Epping to Thornleigh Third Track Proposal. Application number SSI 5132.

I/we object to the Epping to Thornleigh Third Track Proposal and consider that the EIS is inadequate and does not address the full impact of this proposal. It will cause untold damage to the health of residents and to the fabric of the Beecroft Cheltenham Heritage Conservation Area. Do not approve this project, reconsider the alternatives and protect the community.

Figure 5.6 Cross-section and elevation - New Cheltenham Station concourse building
Note: Indicatively added to future design

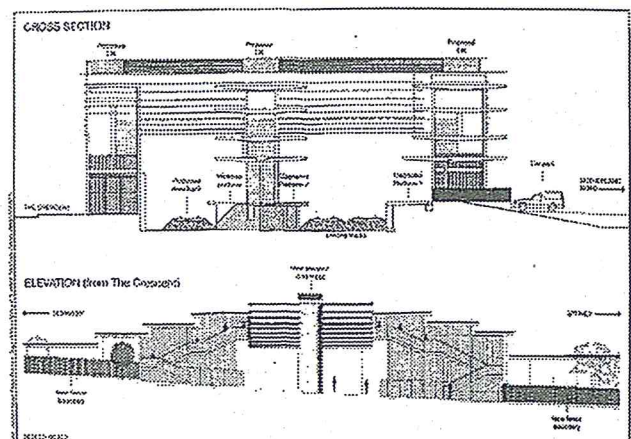
- The proposed redevelopment of Cheltenham Station shows no regard for the HCA. The visual impact of the proposed 13m high glass and steel concourse is totally unacceptable in this HCA.

Concept design drawing of proposed changes to Beecroft Station (Parsons Brinckerhoff 9/3/12). Former side platform shaded in pink.

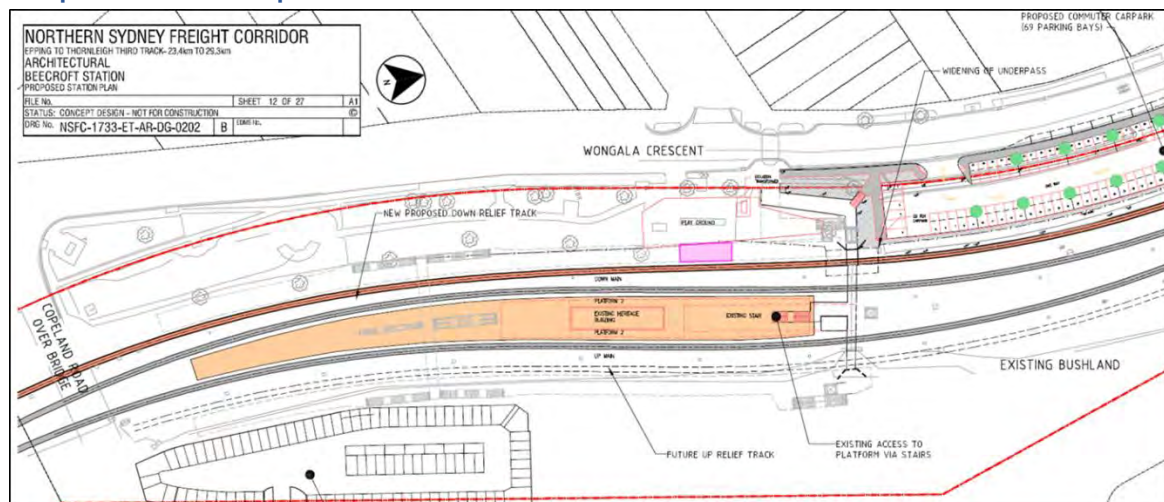
- There has been inadequate assessment of the project's impact on the fabric of the Beecroft Cheltenham Heritage Conservation Area (HCA).
- The plan given for Beecroft Railway station Precinct is vague. The relationship to the trees, playground and original 1895 platform located south of the present station is not shown. A fourth track is shown on the eastern side. The plan does not include urgently needed lifts to allow disabled access at Beecroft Station.

- Beecroft Station Gardens have a heritage listing with Hornsby Council but the impact on them has not been adequately addressed. No arborist's report is given for the trees which will be removed.
